**Subject: Geotechnical Report Addendum
Mercer Island 3-Lot
7621 Southwest 22nd Street
Mercer Island, Washington
RGI Project No. 2020-404-1**

References: 1. Geotechnical Engineering Report, prepared by The Riley Group, Inc. dated September 15, 2020 and updated May 4, 2022.
2. Geotechnical Engineering Report Addendum, prepared by The Riley Group, Inc. dated May 4, 2022.
3. Peer Review Comments, prepared by Michele Lorilla dated May 31, 2022

As requested, The Riley Group, Inc. (RGI) has performed a geotechnical study for the above referenced site and prepared the referenced geotechnical engineering report. RGI also reviewed the City of Mercer Island peer review comments dated May 31, 2022. The review comments are listed below followed by our responses.

MILESTONE PRELIMINARY SHORT PLAT

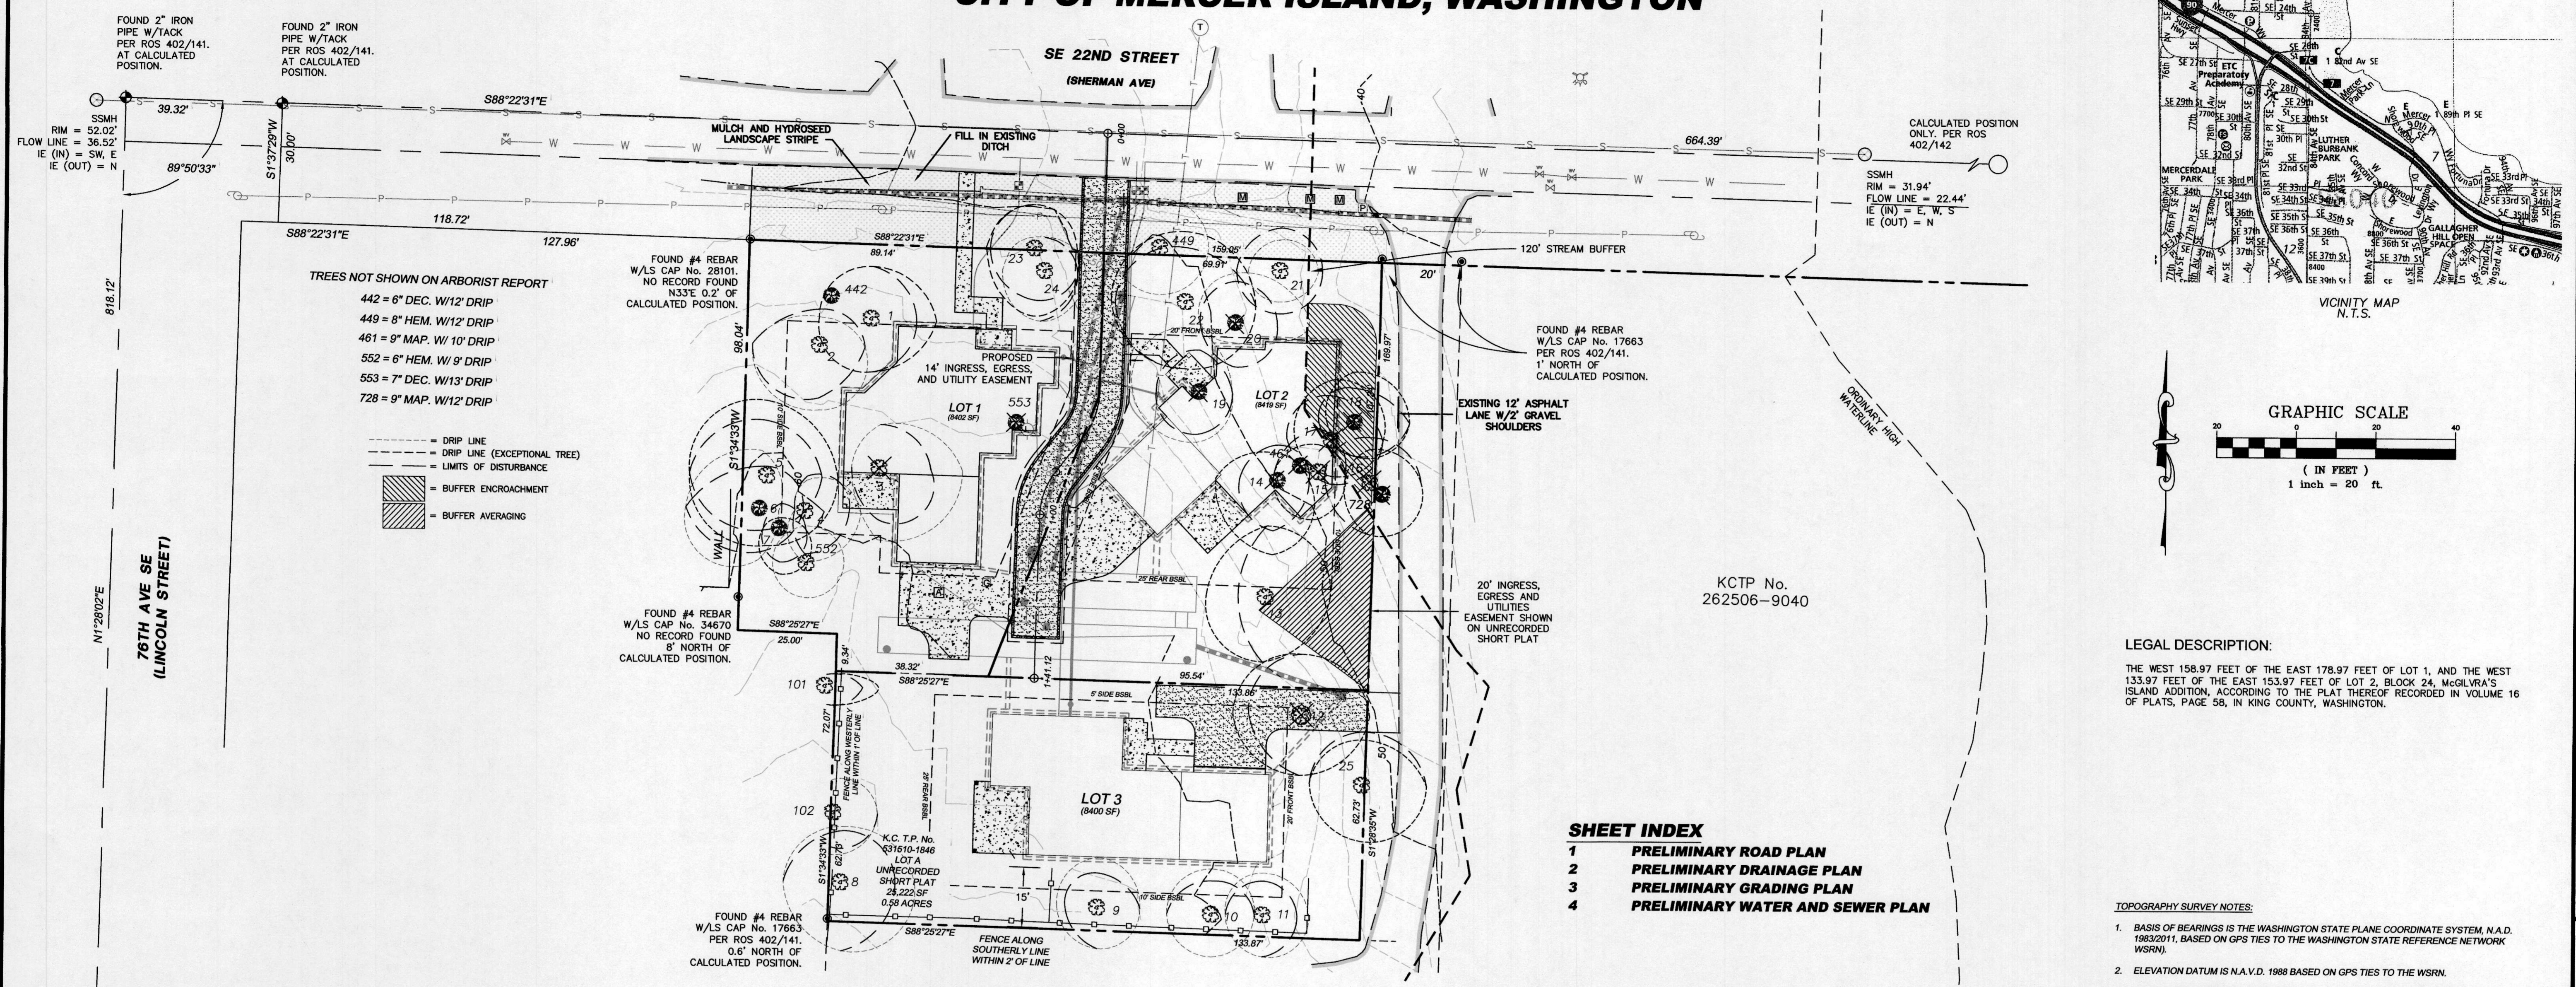
Comment #4 This code section (MICC.09.090) cannot be met without meeting code section MICC 19.07.160. Provide proposed final grades for the proposed lots. Provide information regarding proposed building excavations, e.g., will basement levels be involved? Provide an anticipated basement level elevation or finished floor elevations for at-grade structures for the proposed lots.

Adequate grading information should be provided for Lot 2 so that the geotechnical engineer can assess potential slope stability impacts and provide design mitigation recommendations.

Answer: Based on the current plan, the finished floor elevation will be at elevation 248.8 feet and approximately 3 feet of excavation will be needed to reach the final grade. Since the excavation is so minor, RGI doesn't believe that it will affect the slope stability.
